Application No: BR/244/20/PL
Site Address: The Beach Hotel, former Mud Club Waterloo Square Bognor Regis PO21 1SU
Description of works: Redevelopment into 11 No. 2 bed apartments & 2 No. commercial units (A1 Retail or A3 Restaurant/Cafe) (resubmission following BR/282/19/PL). This application affects the character & appearance of The Steyne, Bognor Regis Conservation Area & may affect the setting of listed buildings. This site is in CIL Zone 4 (Zero Rated) as flats & other development.

Thank you for your internet representation made on 24th November 2020 which has been recorded as no objection with the comments as follows:

Document Title:
 Norfolk Street Elevation 3-3

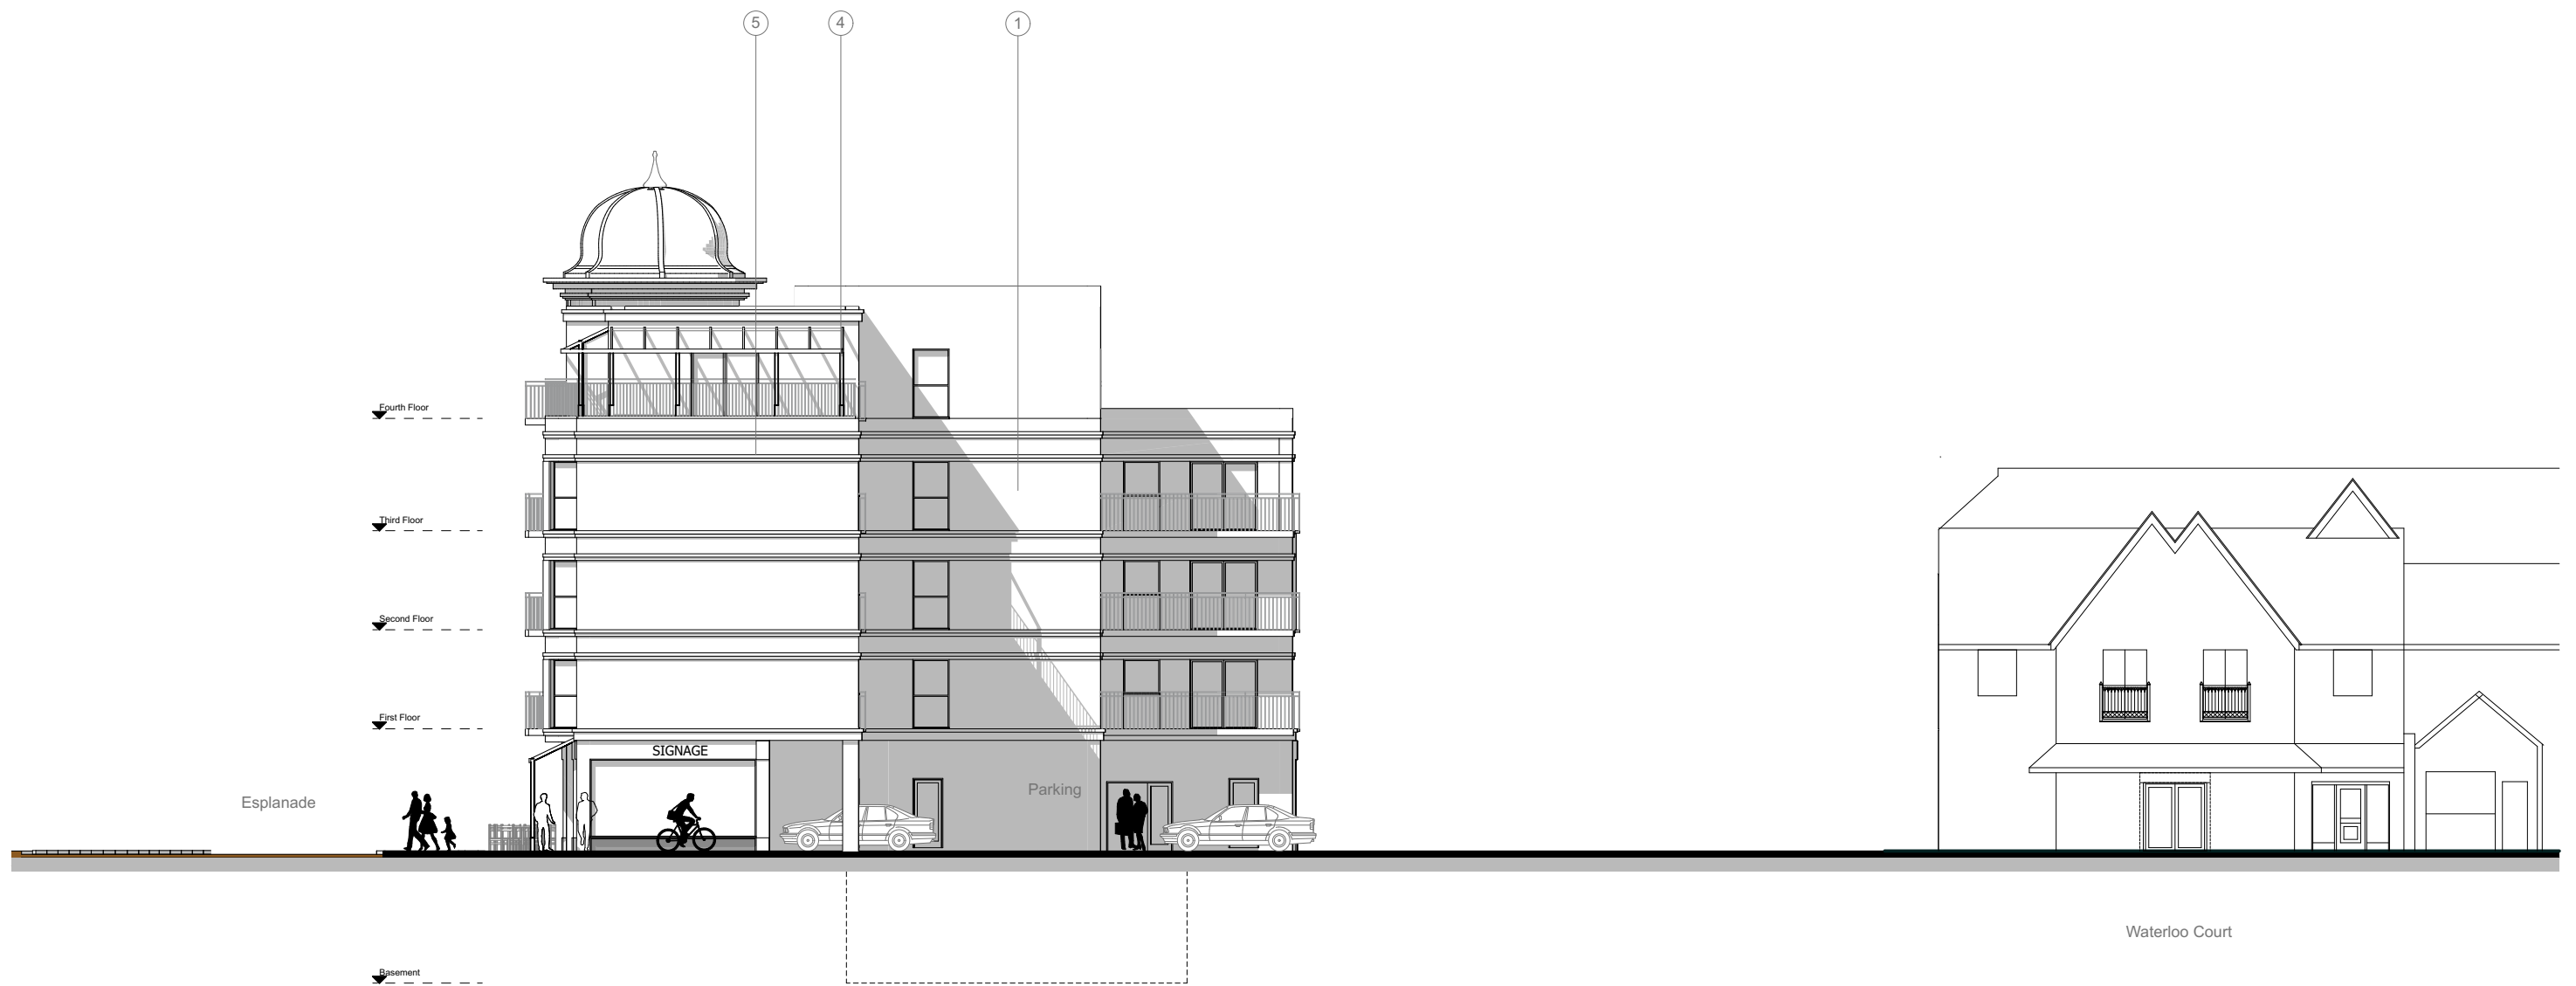
A pale colour ground for the building is very appropriate but great care will be needed over the choice of the white brick given the local coastal climate. There is the danger of quick discolouration if a poor quality or inappropriate brick is chosen. An alternative may be the use good quality pale coloured render or the use of pale yellow London stock bricks which have been used historically in places in the town e.g 1 & 2 Sidlaw Terrace, Clarence Road. The fenestration needs to be of high quality materials e.g powdered coated aluminium, and windows and doors need to be set well back within their reveals and not flush with external walls. Precise details of cornices and parapets also need to be agreed.
